Petition # 1985-59c

OFFICIAL REZONING APPLICATION MECKLENBURG COUNTY

85-59(c) Withdraw Family Trust

ZONING PLAN REVIEW SHEET

**ZONING CHANGE REQUEST MAP
FOR AREA WITHIN
WHEELINGTOWN MOBILE HOME
PARK**

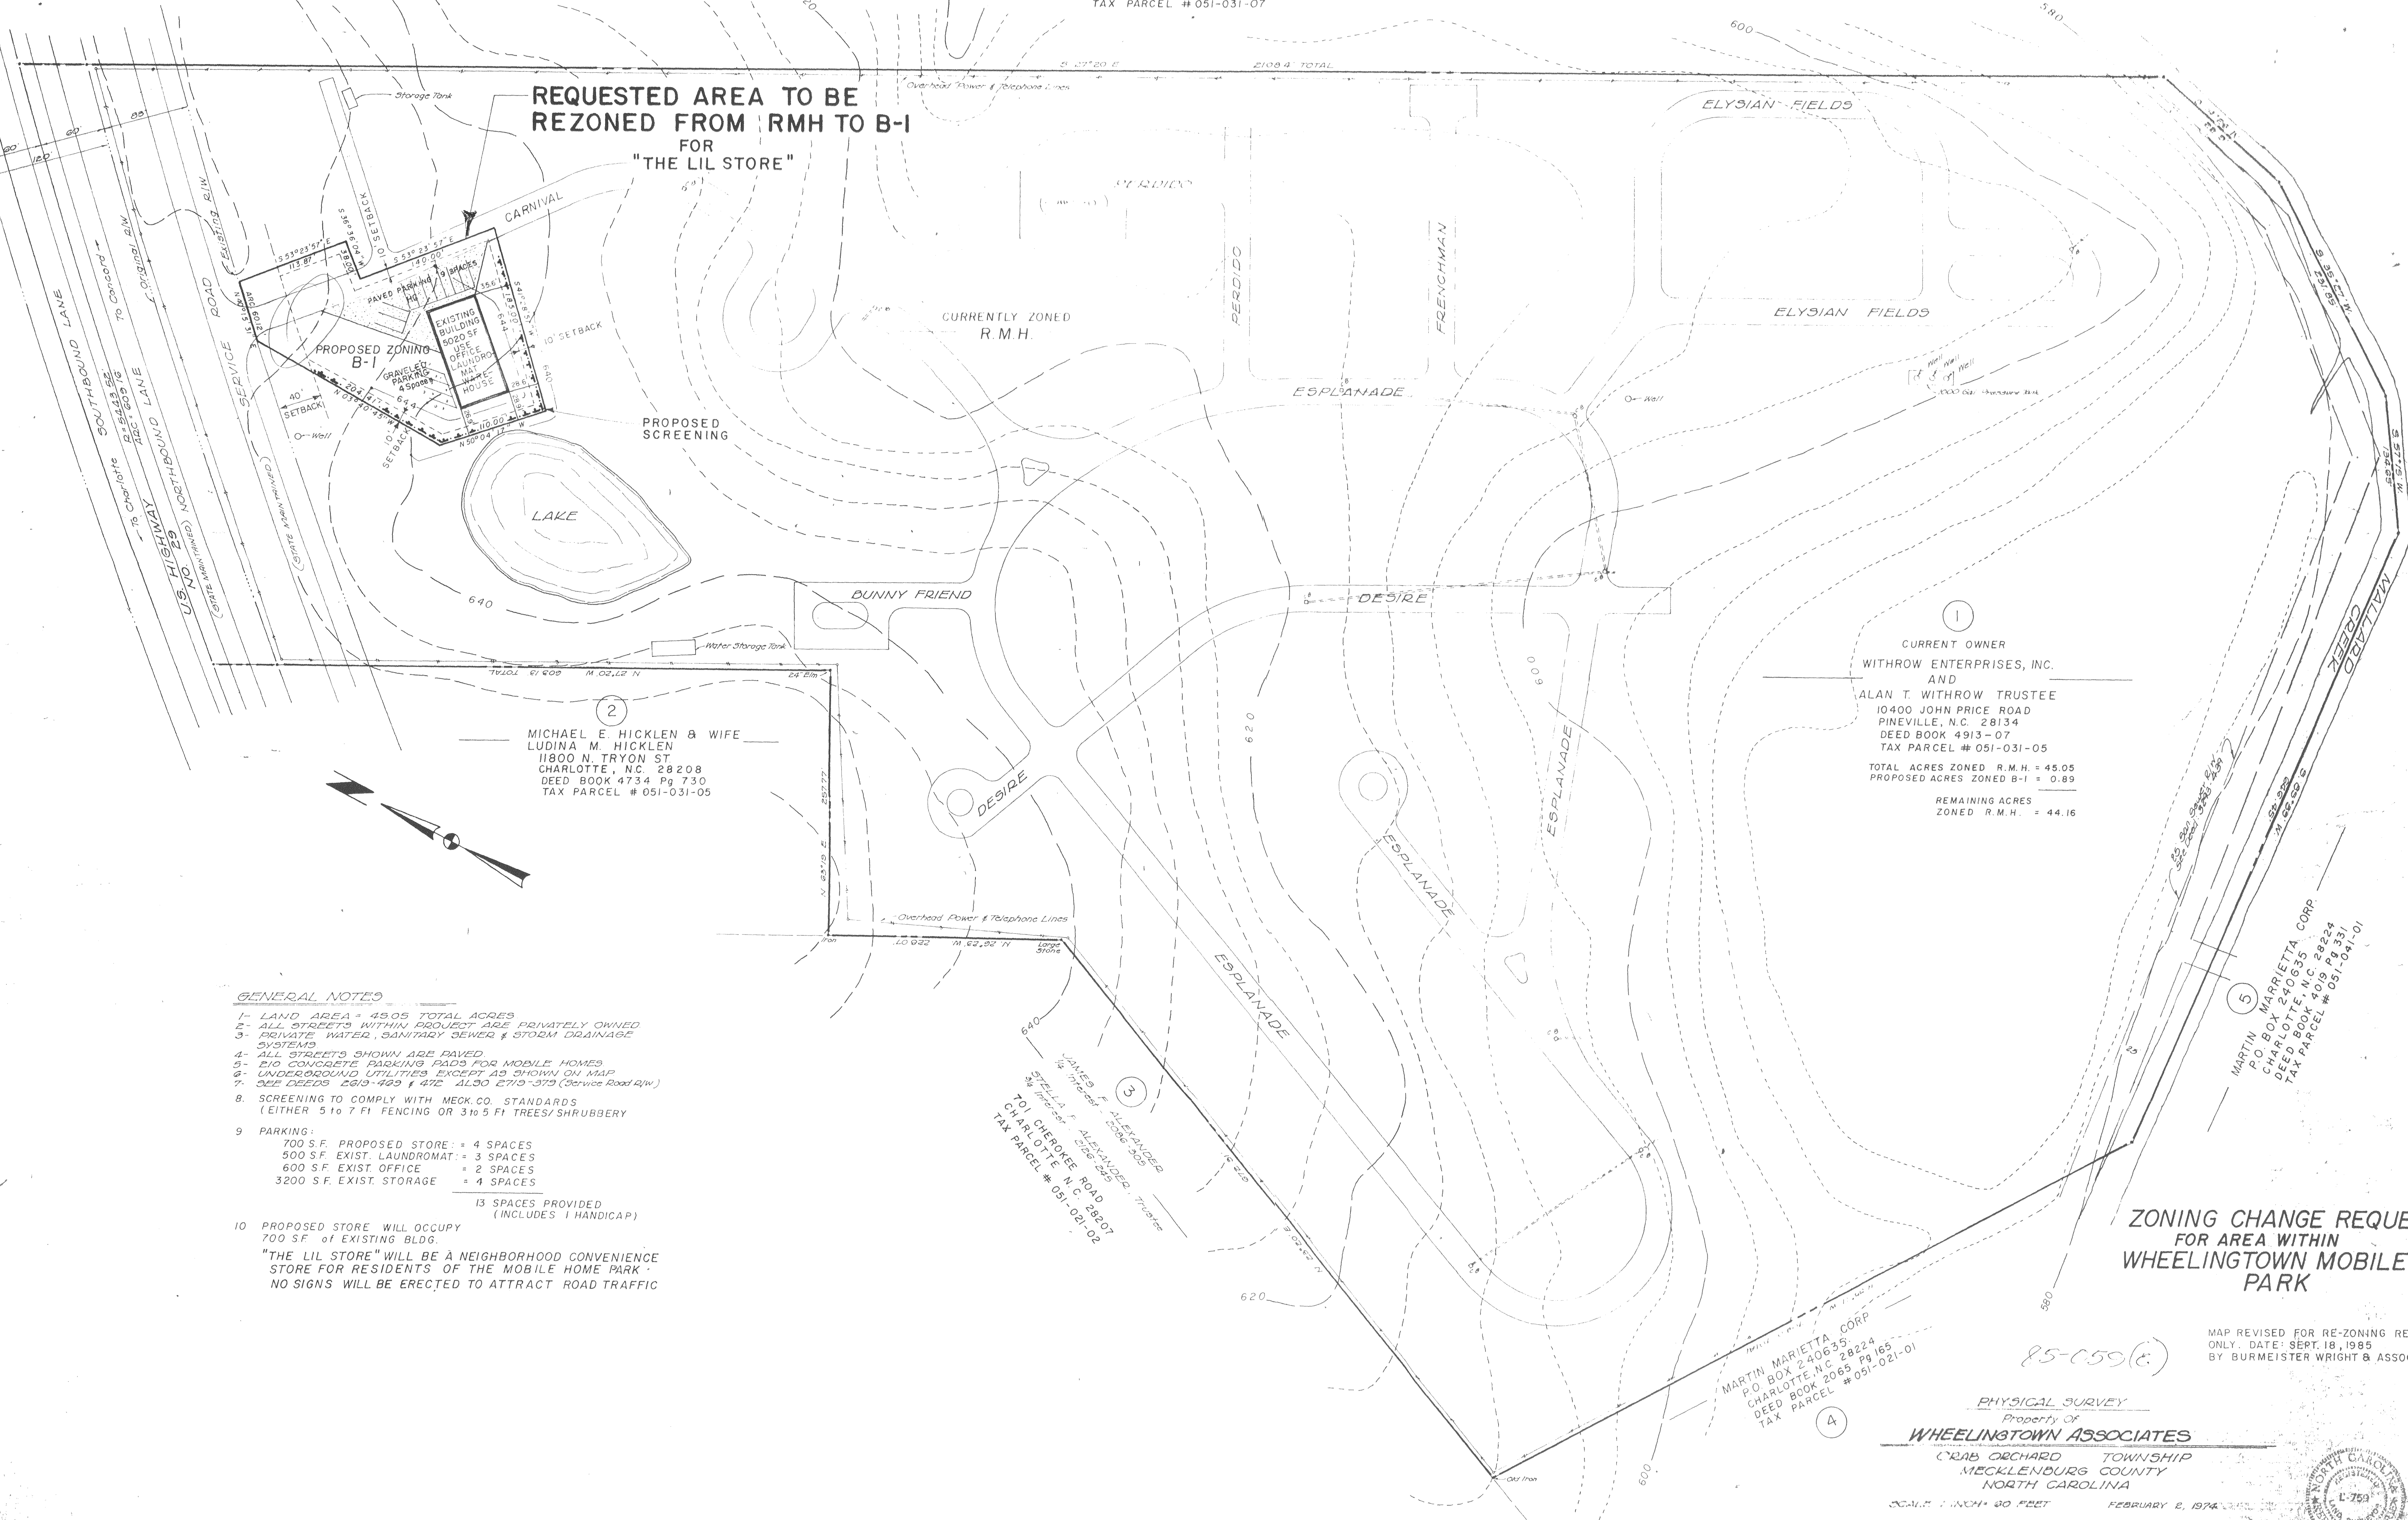
Uch - Entrance to "gravel parking" needs to be better defined. Parking area not efficiently designed
